DECISION DELEGATED TO HEAD OF PLANNING

Application No: H13-0613-22 **Applicant:** Mr J Barnett

Proposal: New dwelling - approved under H13-1021-17. Modification to Condition 2 to allow amendments to previously approved plans and details of external materials, windows & doors (Conditions 4, 6, 7 & 8)

Location: Rear Of 10 High Street Moulton Spalding

Planning (Elevations and Floor Plans)

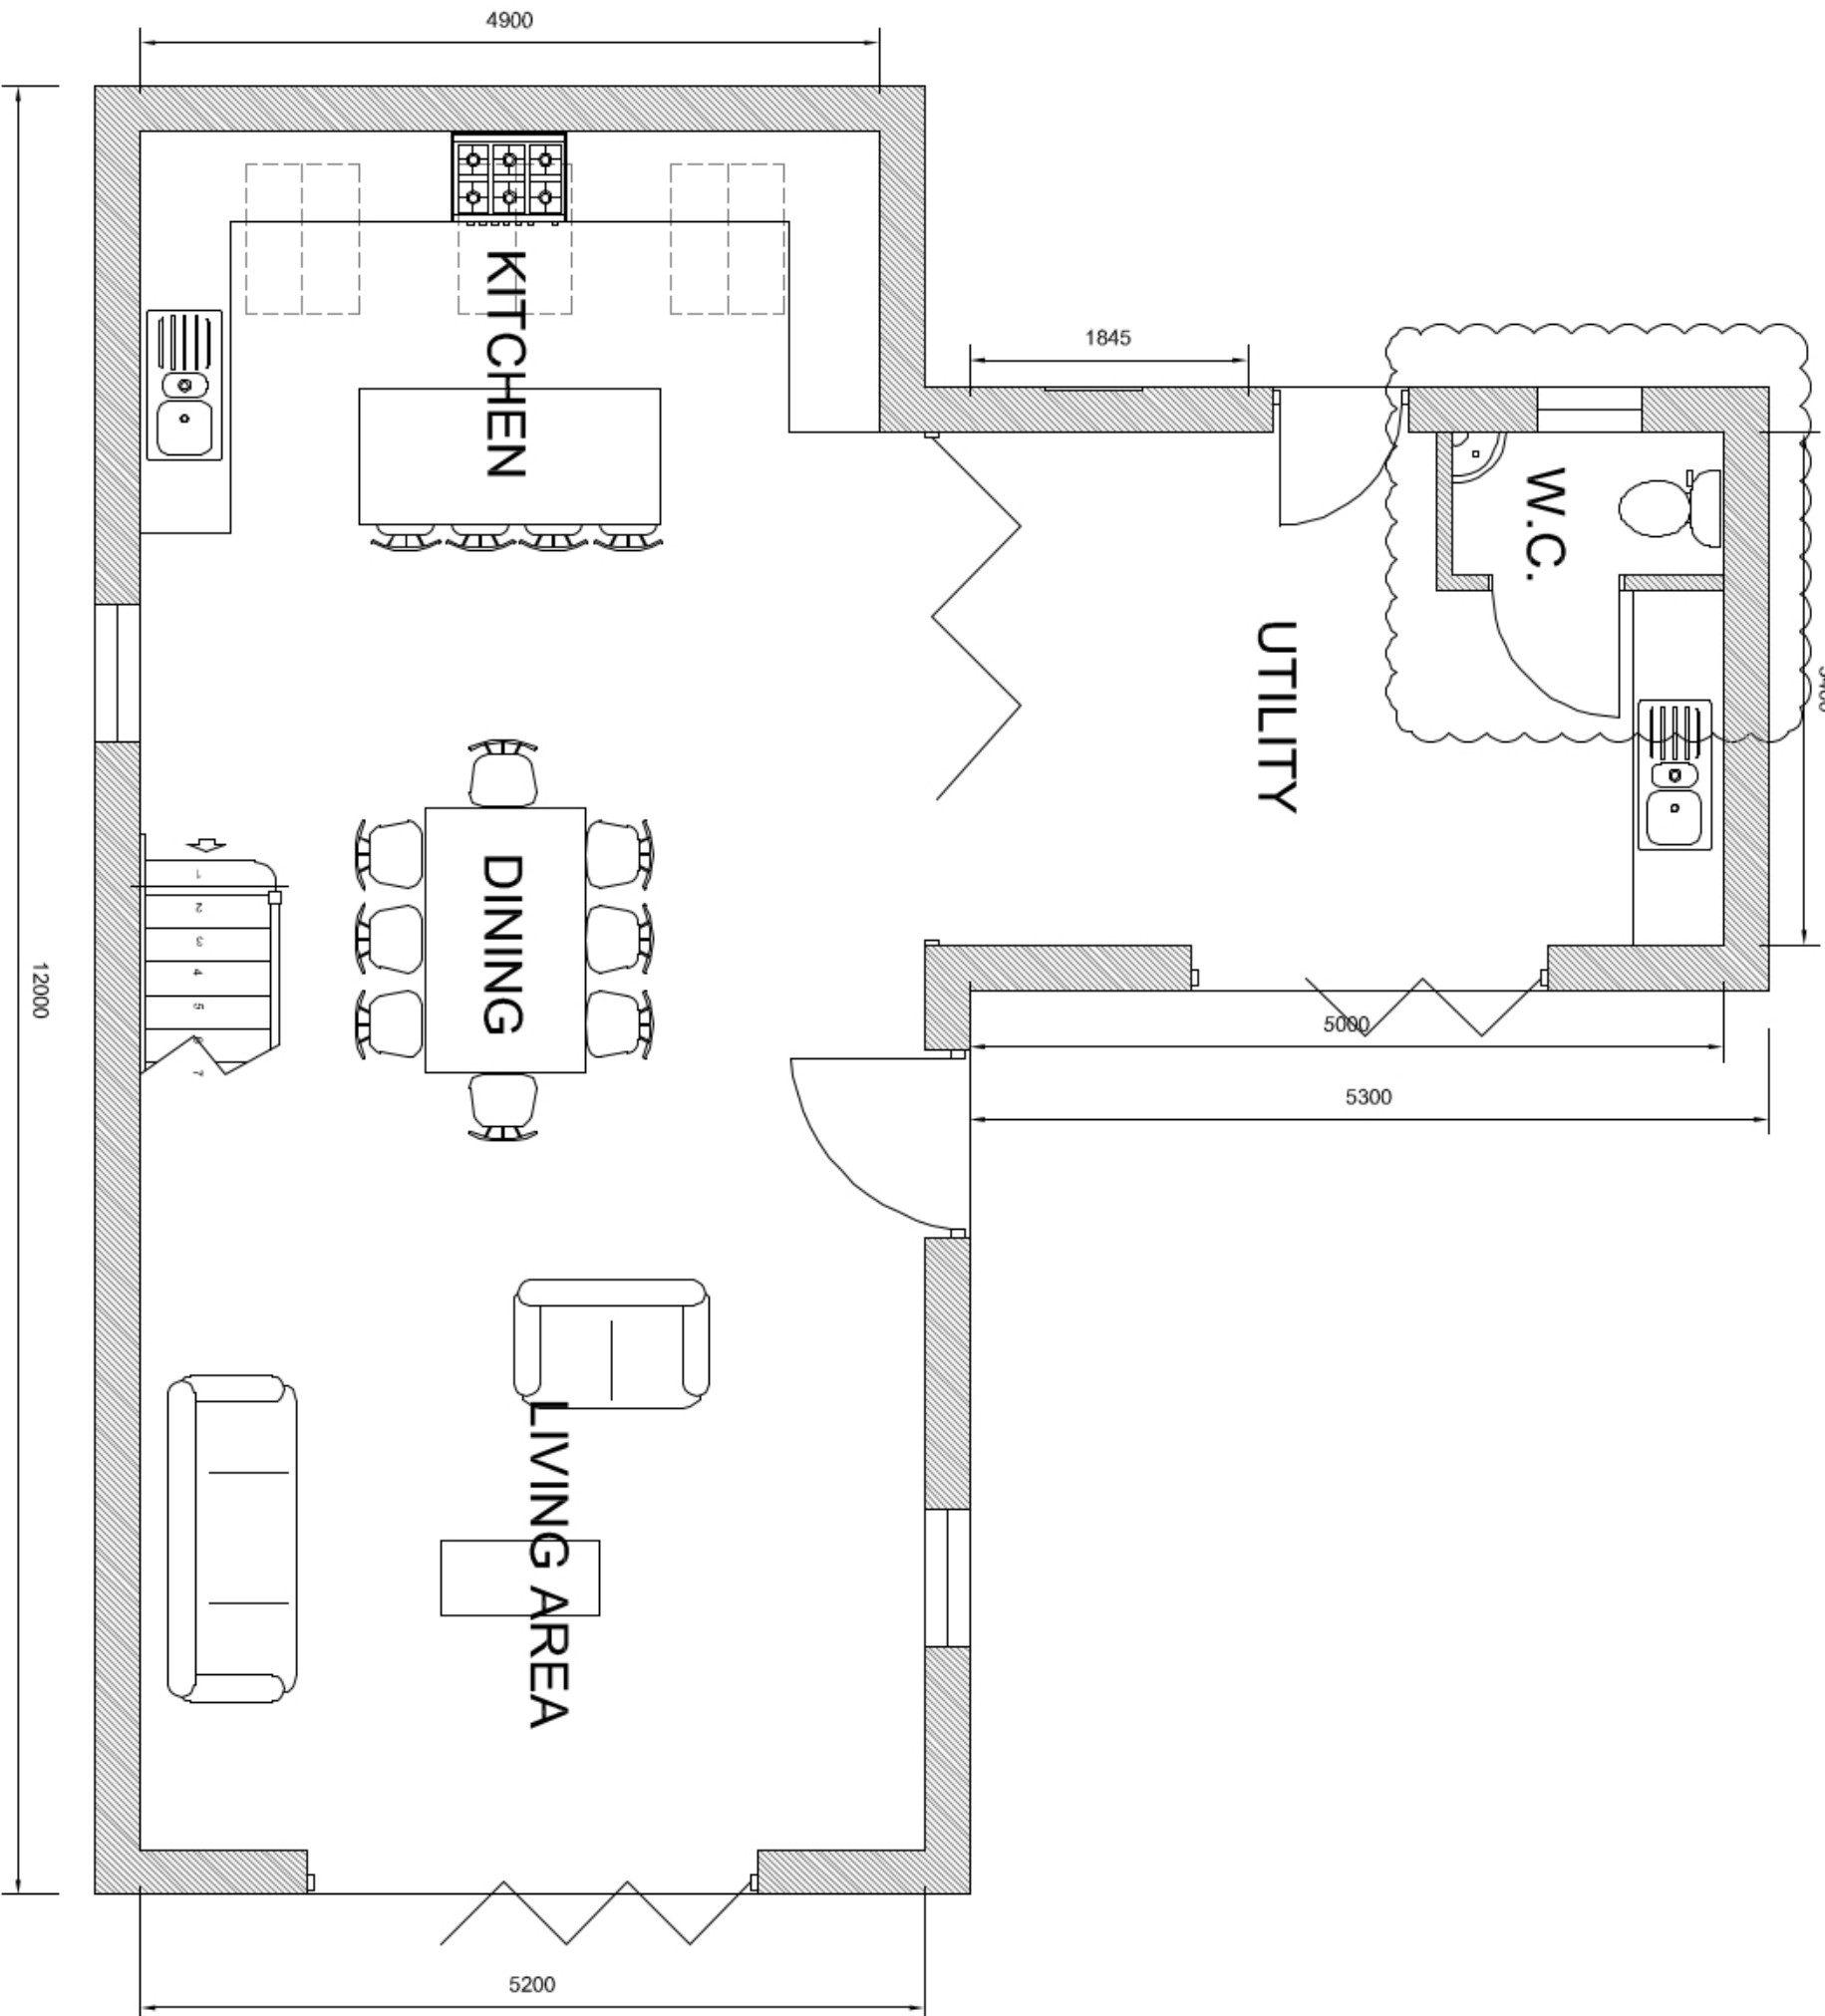
Multiple amendments to the originally approved plans are proposed. The most visually impactful and key alterations are the alteration of the Southern sliding door to feature a brick lintel rather than timber, to alter the design of multiple window frames and to change the proposed brick type to a similar, more readily available type.

The main brick type will Imperial Handmade Olde Reclamation Clamp with details achieved with the contrasting Imperial Handmade Soft Red. The roof will be tiled with Spanish Natural Slates of equal size to those which are featured on the roof of 10 High Street. These materials are deemed to be appropriate to the proposal.

The applicant wishes to retain the existing detail of the sectional nature of the windows, however, the oak header is to be replaced with a brick soldier course. This alteration is deemed to be appropriate to the proposal.

All proposed window units are timber casement style, featuring either 2 or 3 glazed panels. These are deemed wholly appropriate.

The proposed modification of condition 2 will not cause any negative amendment to the residential amenity of any nearby properties. In fact, the removal of the rear, 1st floor window will now

completely remove any risk of overlooking the gardens of the residential property immediately to the West.
